# CITY OF ALBUQUE

**Re: Winter Green Apartments – 10932 Golf Course Rd NW.  
ESC Plan Engineers Stamp Date: 10/6/2021 – A12E008D**

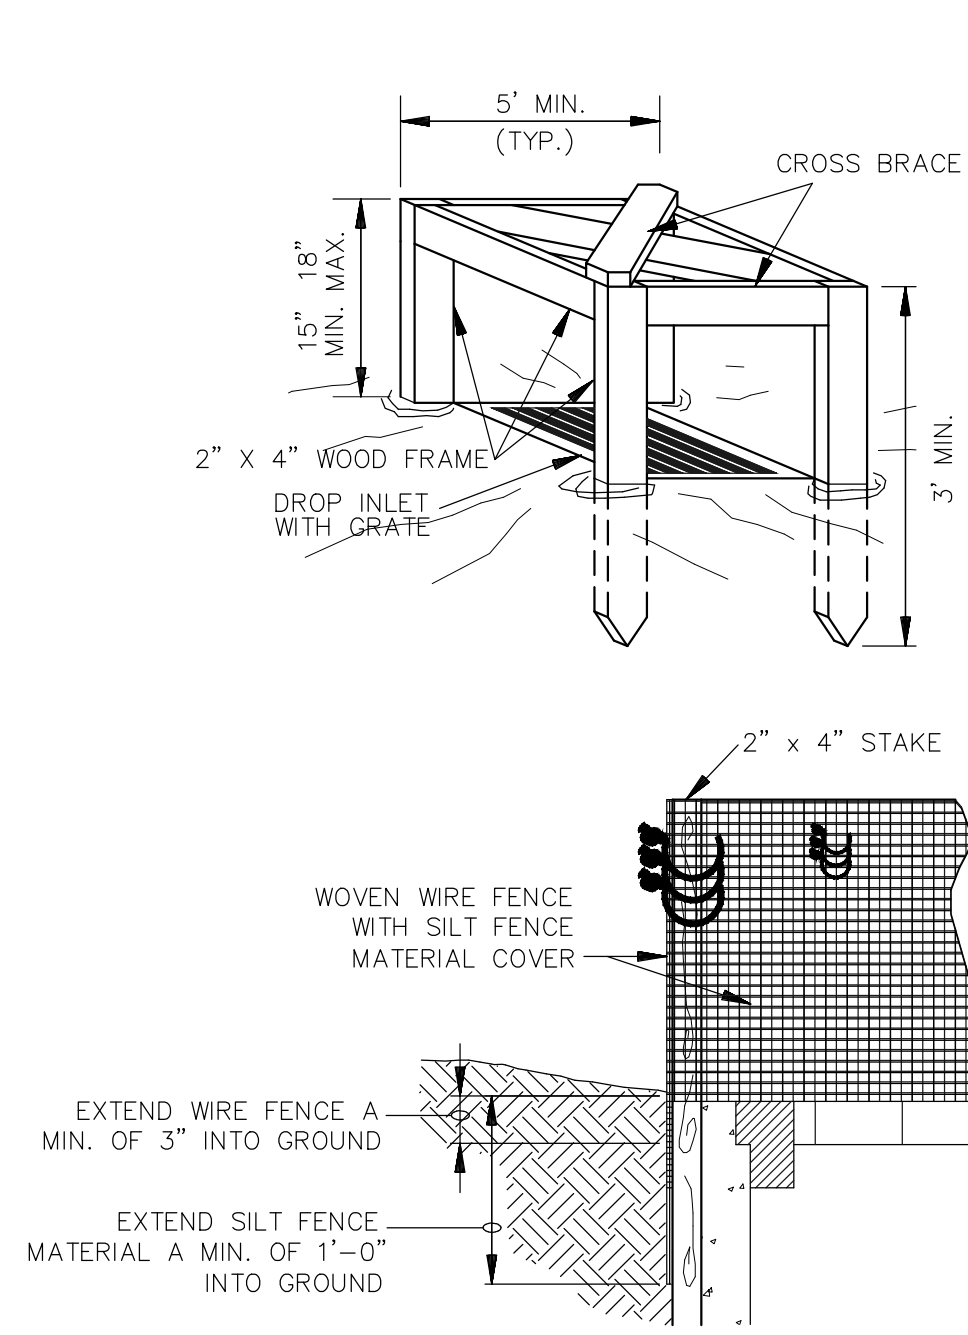
3. Stabilization measures are not identified on the Landscape Plan for the grading on the adjacent parcel to the north. Erosion Control note 7 on sheet C7.2 covers the deadlines, but General Erosion Note 'O' would be more specific and accurate if it says Temporary Cover and Final Stabilization (Part 2.2.14 (a) and (b) respectively) are to be per COA STD SPEC 1012 Native Seed with Hydromulch and Aggregate Mulch respectively.

ENGINEER'S SEAL	WINTERGREEN LUXURY APARTMENTS 10800 GOLF COURSE RD. NW	DRAWN BY RG
	ESC DETAILS	DATE 10/06/2021
	TERRA WEST, LLC 5571 MIDWAY PARK PLACE NE ALBUQUERQUE, NM 87109 (505) 858-3100 www.tierrowestllc.com	2020013_SWPPP
RONALD R. BOHANNAN P.E. #7868	10/06/2021	SHEET # C7.4
		JOB # 2020013

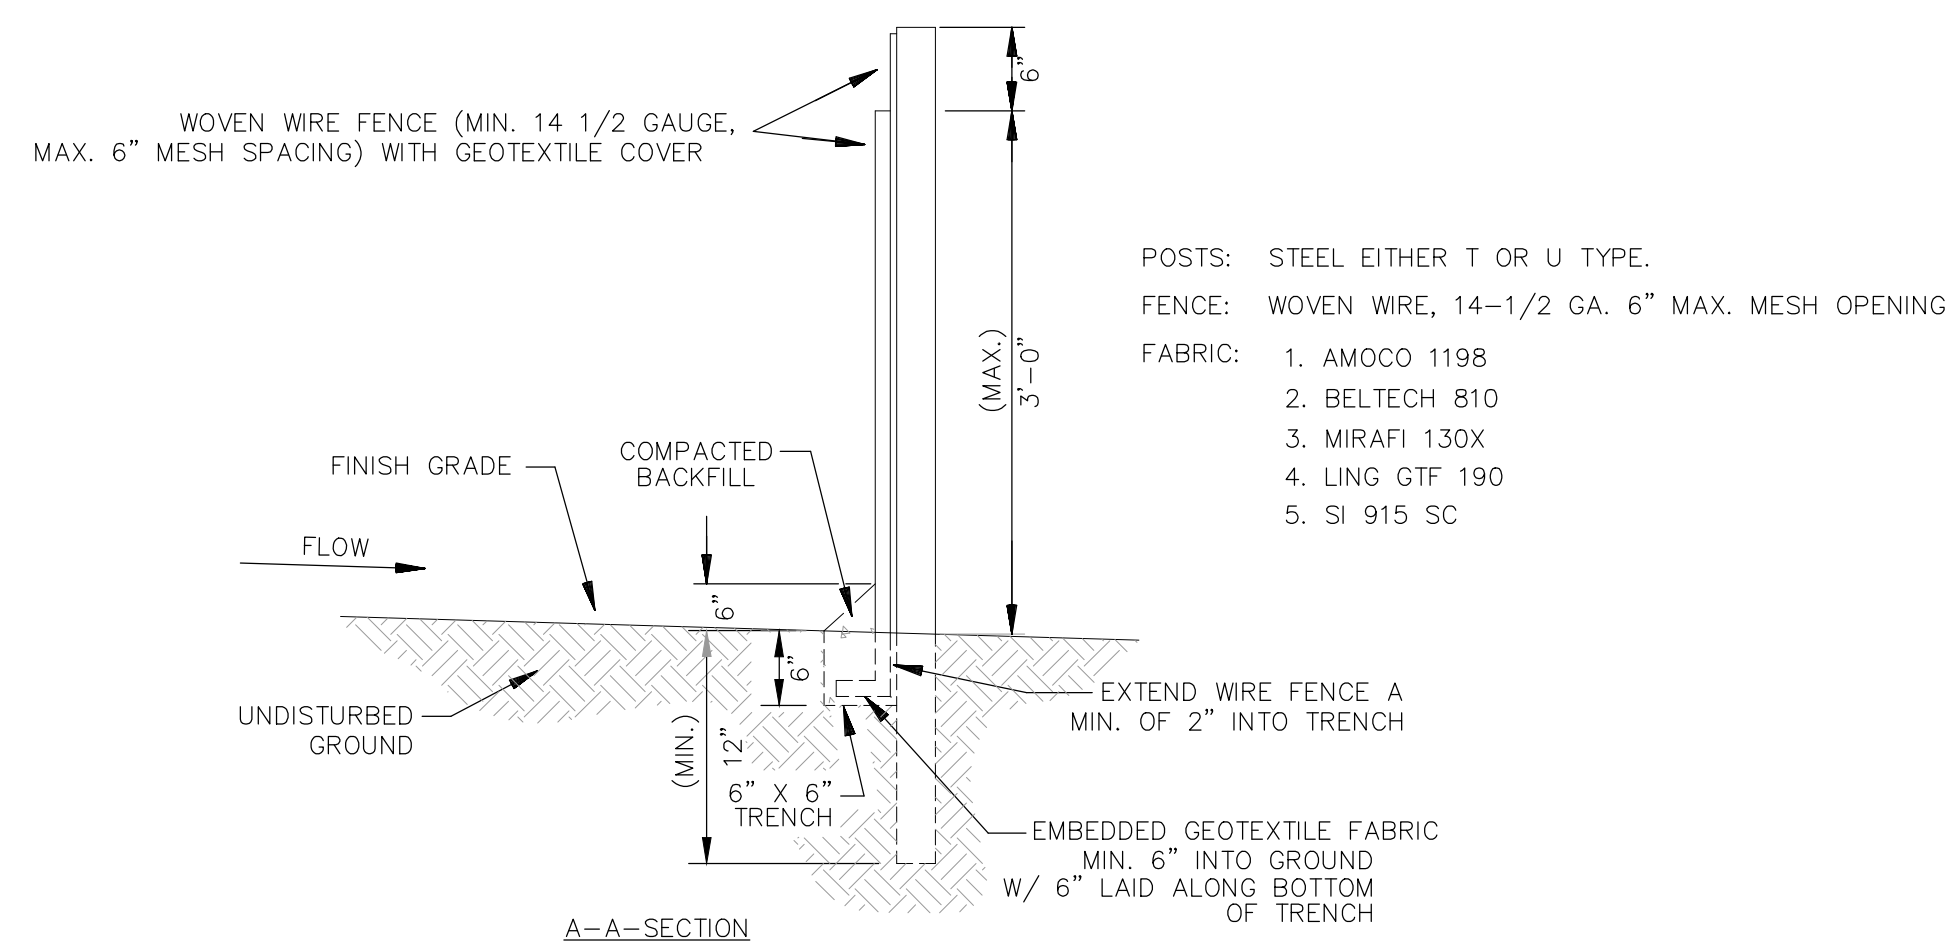
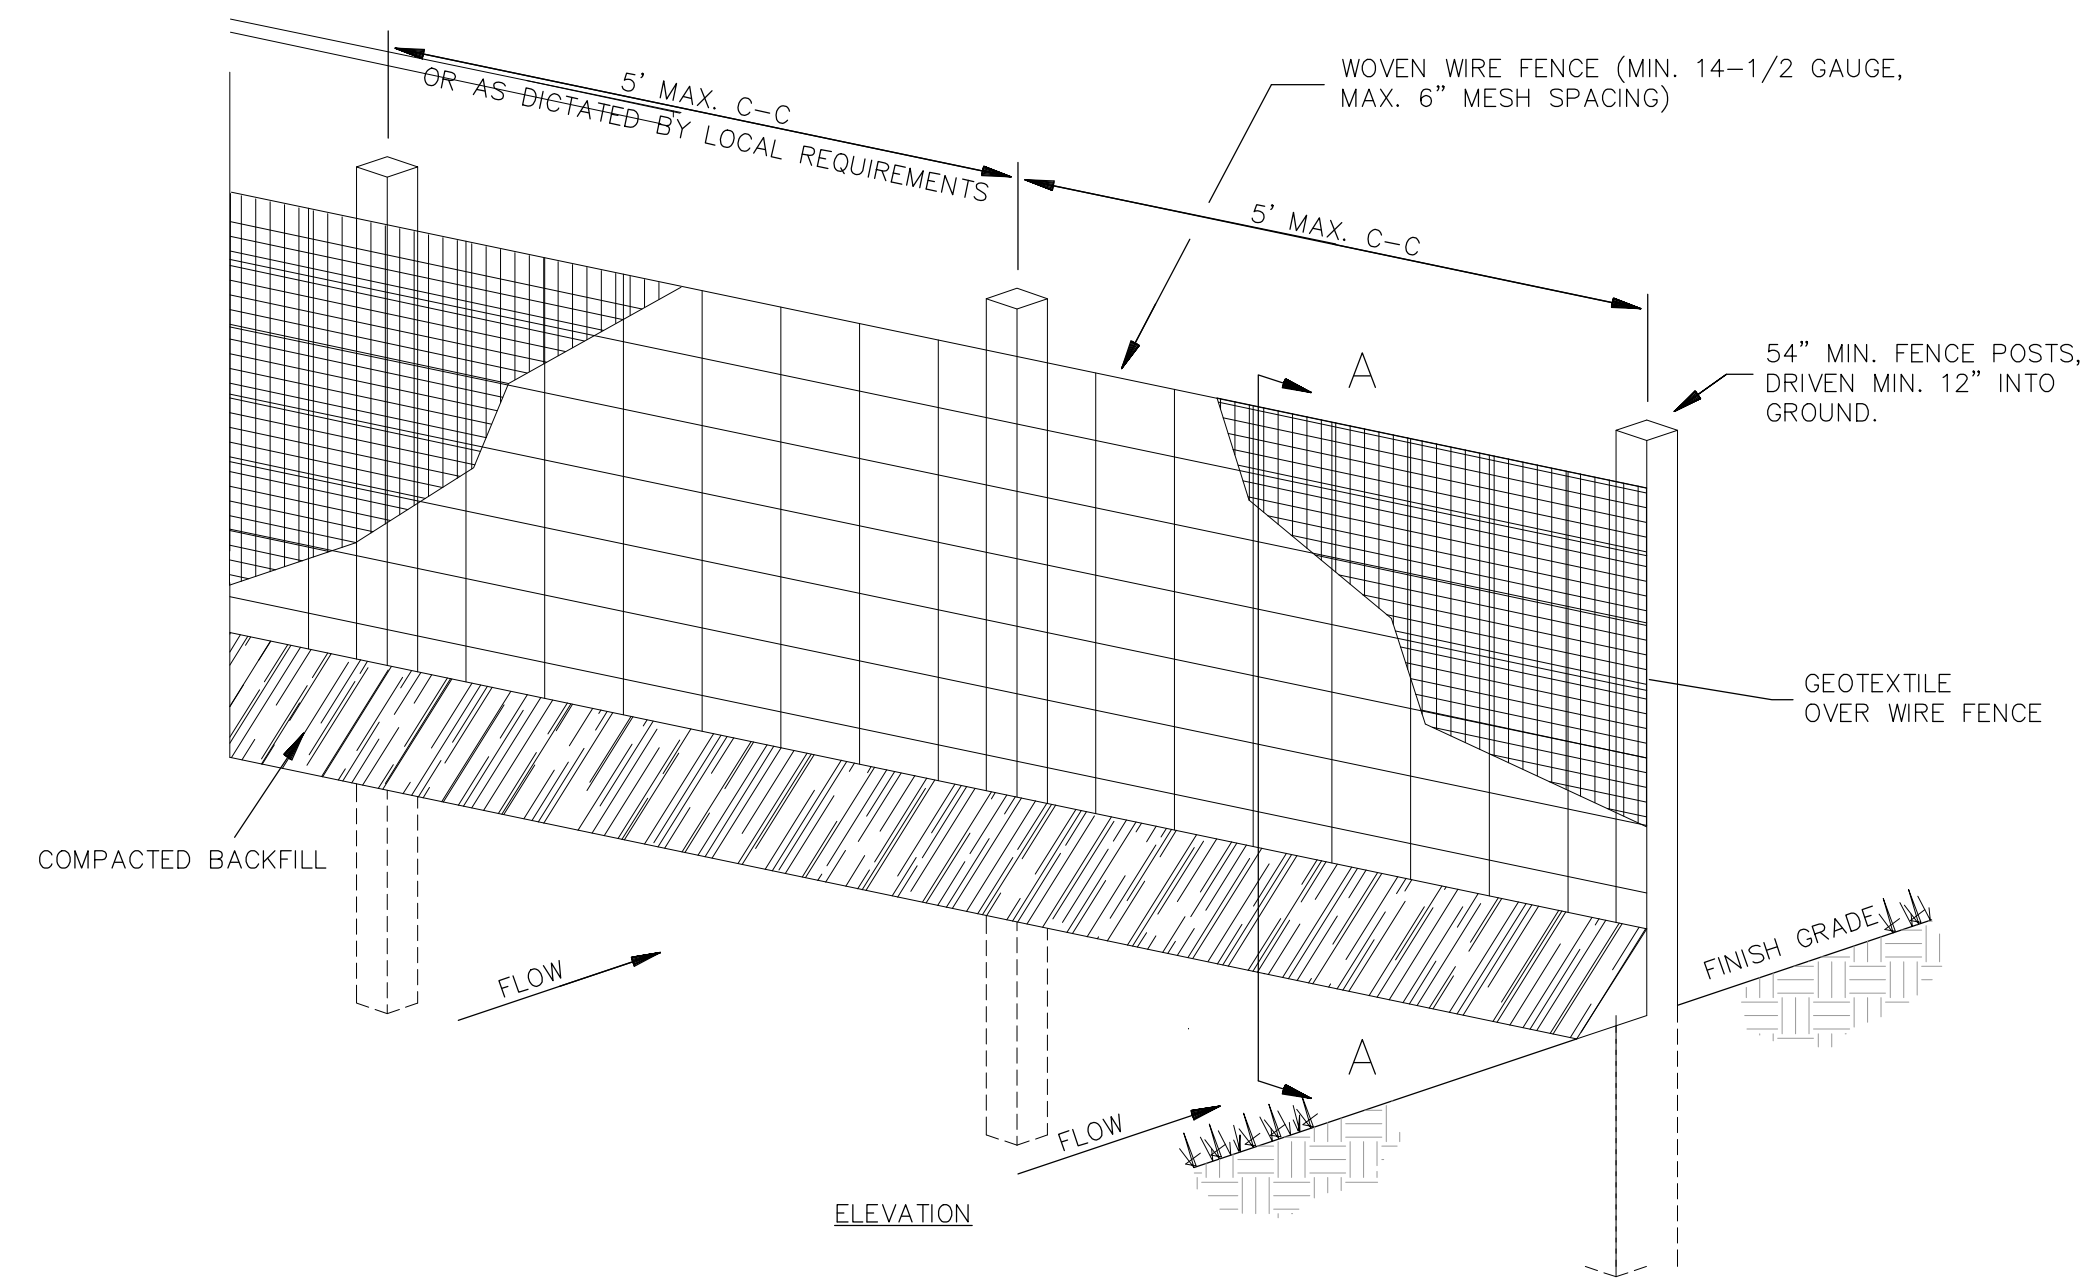
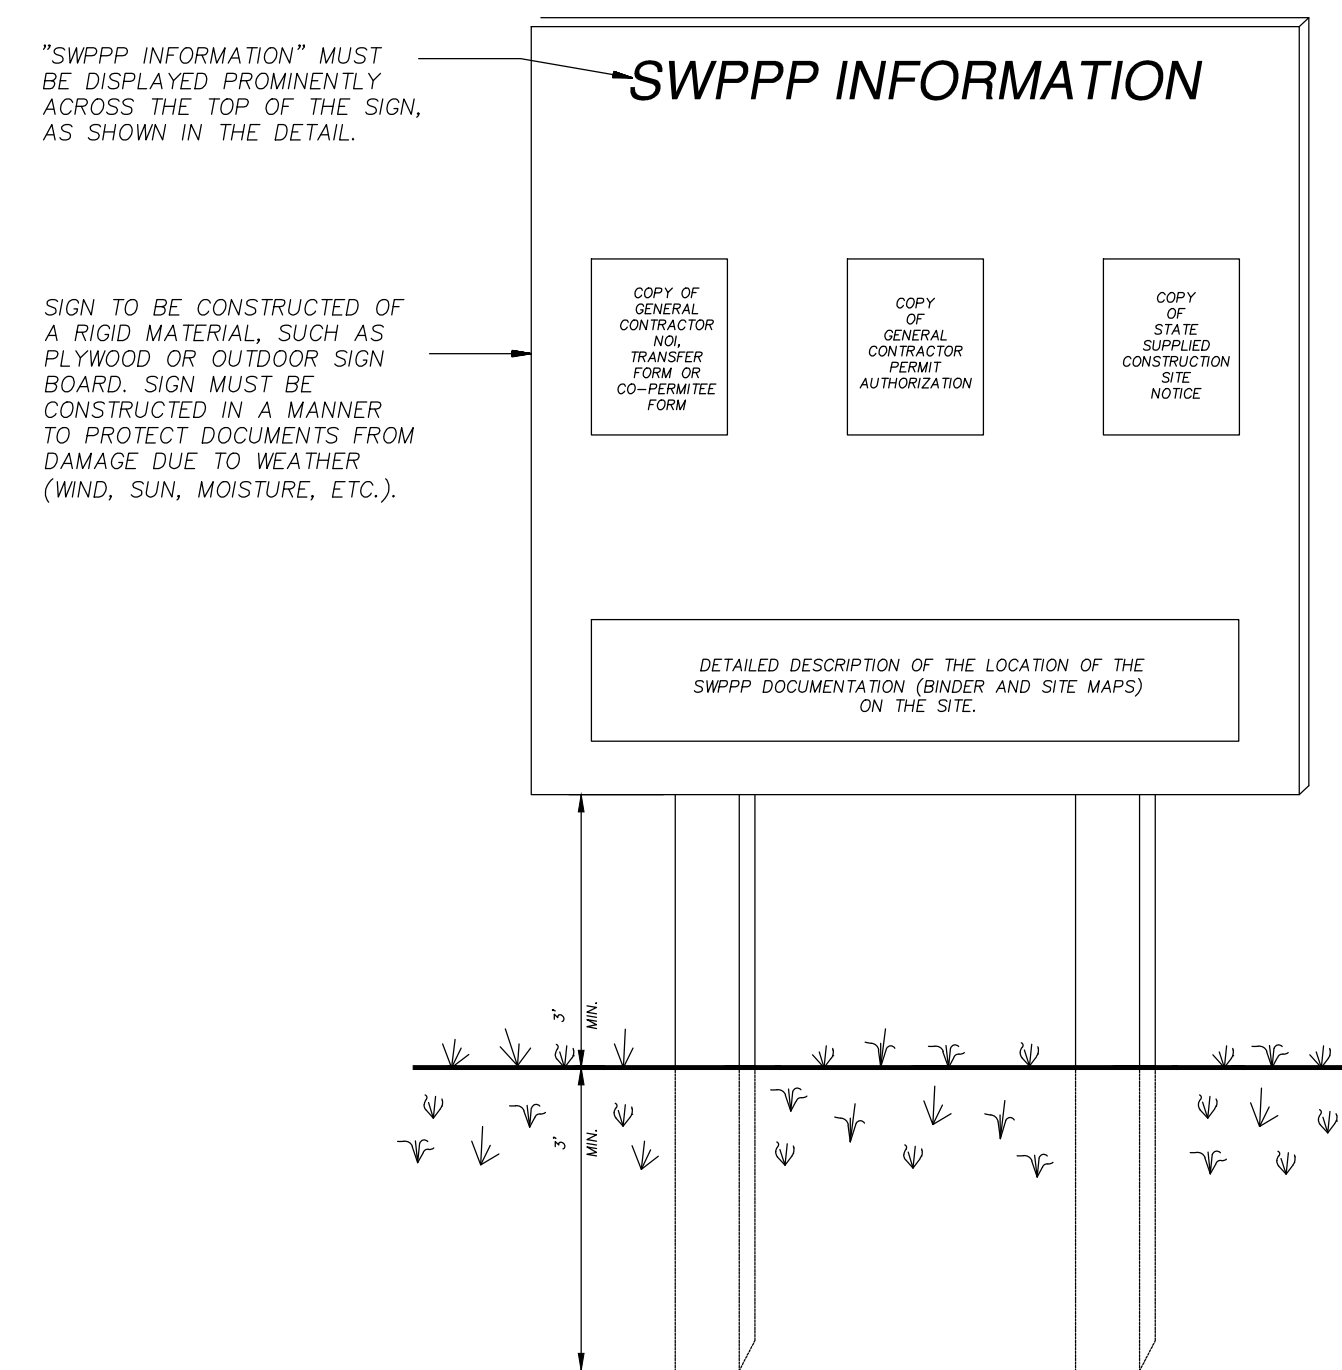
4. More detail is needed for the outlet structure at SB#3.
